City of Albuquerque Stormwater Construction Site Inspection Report

Project Name and Location	Fiesta Kia Albuquerque 7400 Lomas Blvd NE		
Site Contact Name & Agency	Rick Gonzales Brian	ESC File No. NPDES ID No.	K19E152
Date of Inspection	10-23-18	Start/End Time	11:05/11:25
COA Inspector Name	Curtis Cherne, Stormwater Quality		
Describe Present Phase of Construction	Framing Bldg		
Type of Inspection:	<input type="checkbox"/> Regular <input type="checkbox"/> During storm event <input checked="" type="checkbox"/> Post-storm event (> 0.25 inch) <input type="checkbox"/> 311 / Complaint Response <input type="checkbox"/> Follow-Up

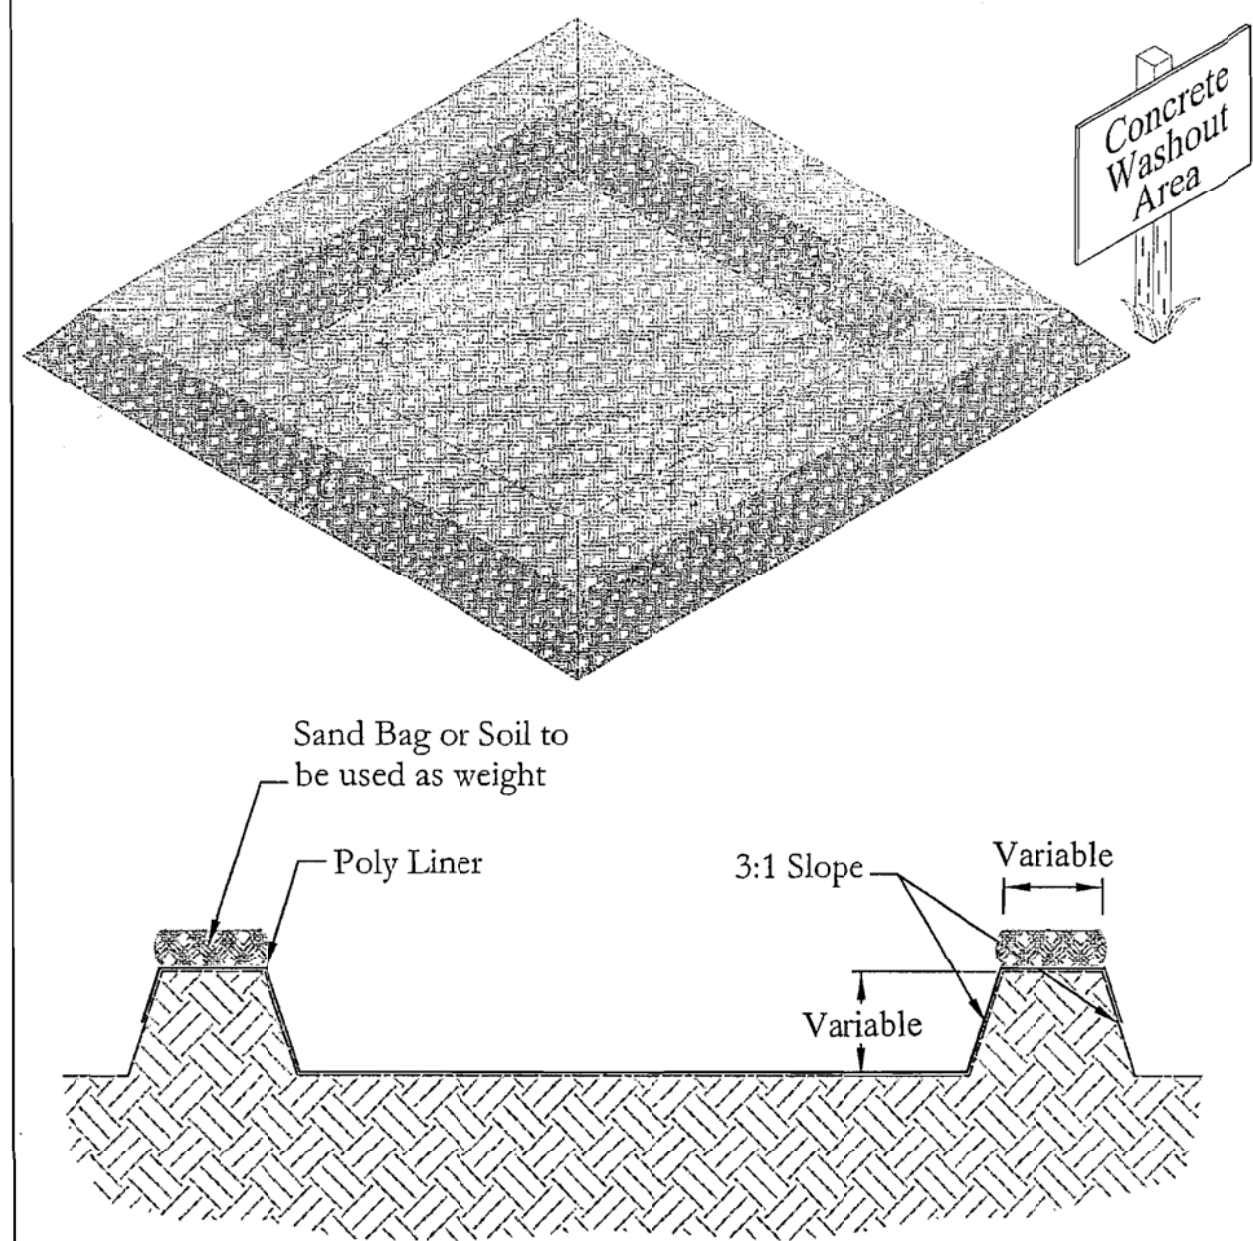
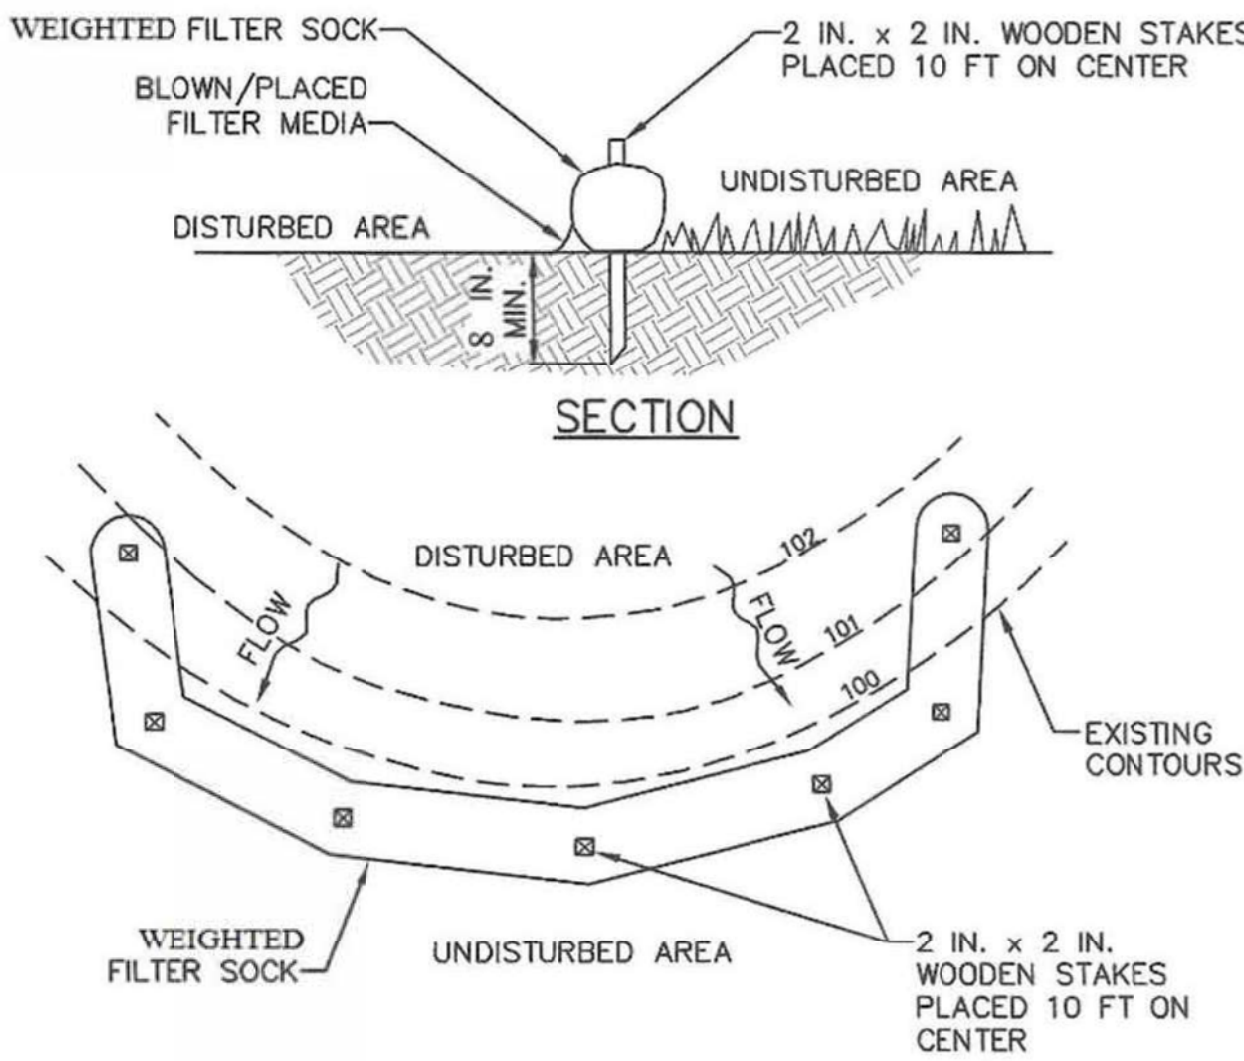
CGP	BMP / Activity	Maintenance Required? (1)	Corrective Action Required? (2)	Location and Notes
1.5	Post a Notice		✓	no posting
2.2.1	Provide and maintain Natural buffer when Waters of the US < 50 ft			
2.2.3	Sediment control along any perimeter		✓	getter sediment water in gutter to channe st
2.2.3	Sediment control along any perimeter		✓	no sediment BMP west end area near Lomas
2.2.3	Sediment control along any perimeter			
2.2.3	Sediment control along any perimeter			
2.2.3	Sediment control along any perimeter			
2.2.3	Sediment control along any perimeter			
2.2.3	Sediment control along any perimeter			east or west end - workers putting
2.2.4	Minimize sediment track-out		✓	no VTC and mobile, track out in middle of Lomas
2.2.5	Manage stockpiles
